DRB Application No.: 09DRB-70273 Project # 1002847
 Project Name: Park Addition
 Agent: The Survey Office, LLC Phone No.:

DRB Comments

PROJECT # 1002847

RE: Lots 5 & 6, Block C, Park Addition

**PLAT OF**  
**LOTS 6-A & 6-B, BLOCK C**  
**PARK ADDITION**  
 PROJECTED SECTION 17, T. 10 N., R. 3 E., N.M.P.M.  
 ALBUQUERQUE GRANT  
 CITY OF ALBUQUERQUE  
 BERNALILLO COUNTY, NEW MEXICO  
 AUGUST 2009  
 SHEET 2 OF 2

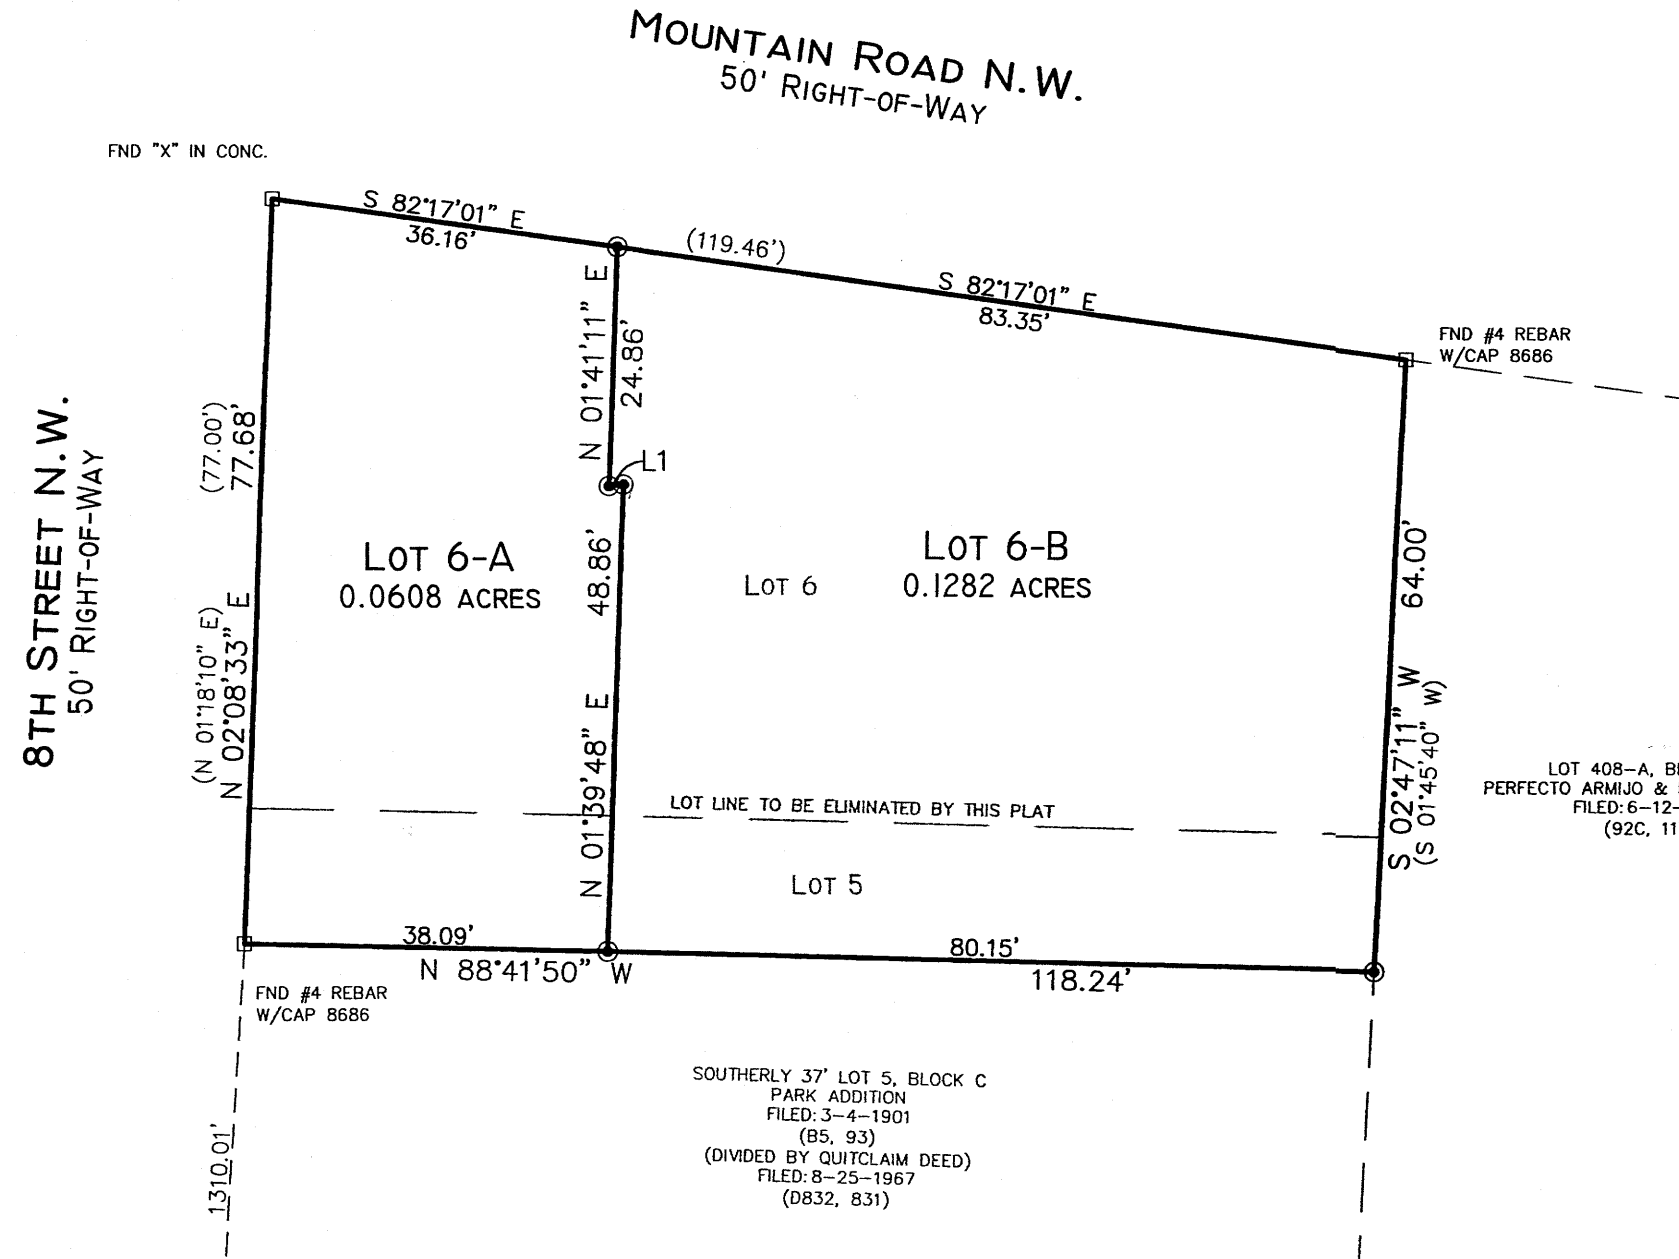
Off street parking requirements need to be demonstrated.
